From: Erin Moore
Sent: Monday, August 26, 2013 3:56 PM
To: Jeff Watson
Subject: FW: BL-13-00020 Suebert

From: Jeff Watson
Sent: Friday, August 23, 2013 3:17 PM
To: Christina Wollman; Brenda Larsen; Jan Ollivier; Holly Duncan; Erin Moore; Joe Gilbert
Subject: BL-13-00020 Suebert

CRUSE & ASSOCIATES
PROFESSIONAL LAND SURVEYORS
217 East Fourth Street P.O. Box 959
Ellensburg, WA 98926 (509) 962-8242
SEUBERT PROPERTY

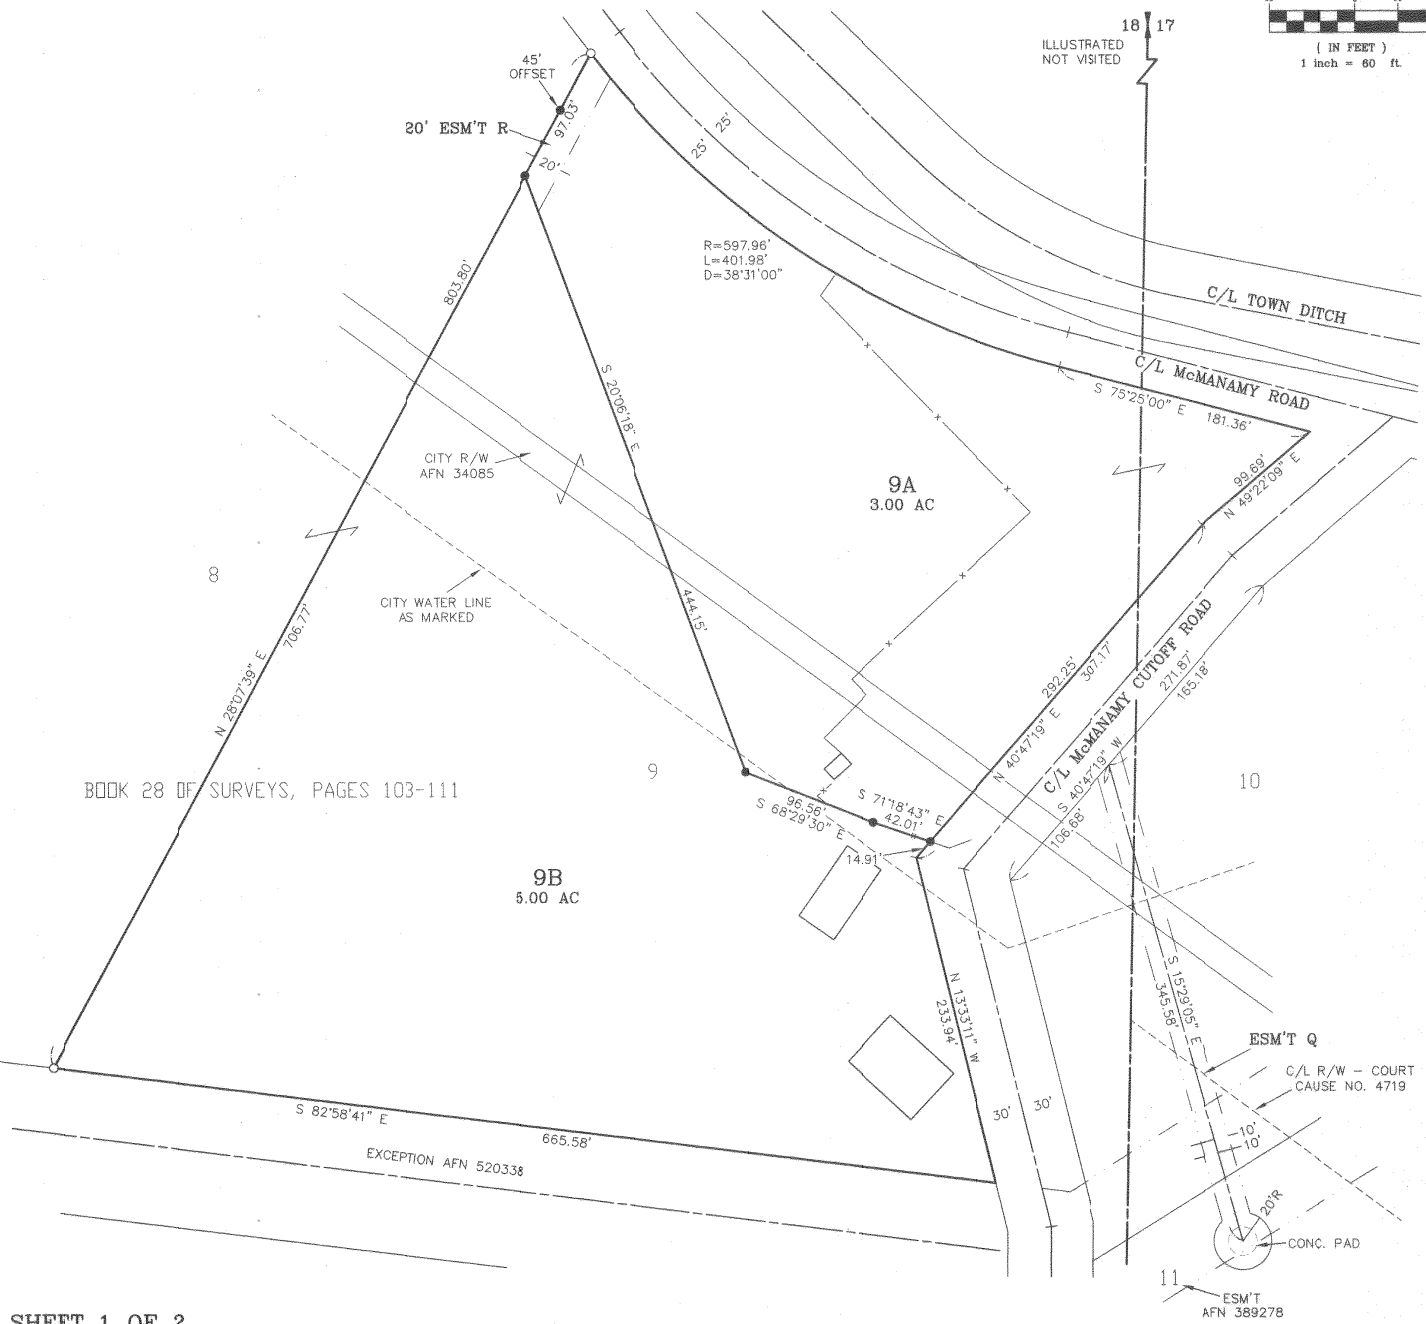
This one should be Ok. There is one proposed lot line that comes close to existing houses and outbuildings for the proposed 3 acre lot but it looks as though it should be far enough away from any existing wells.
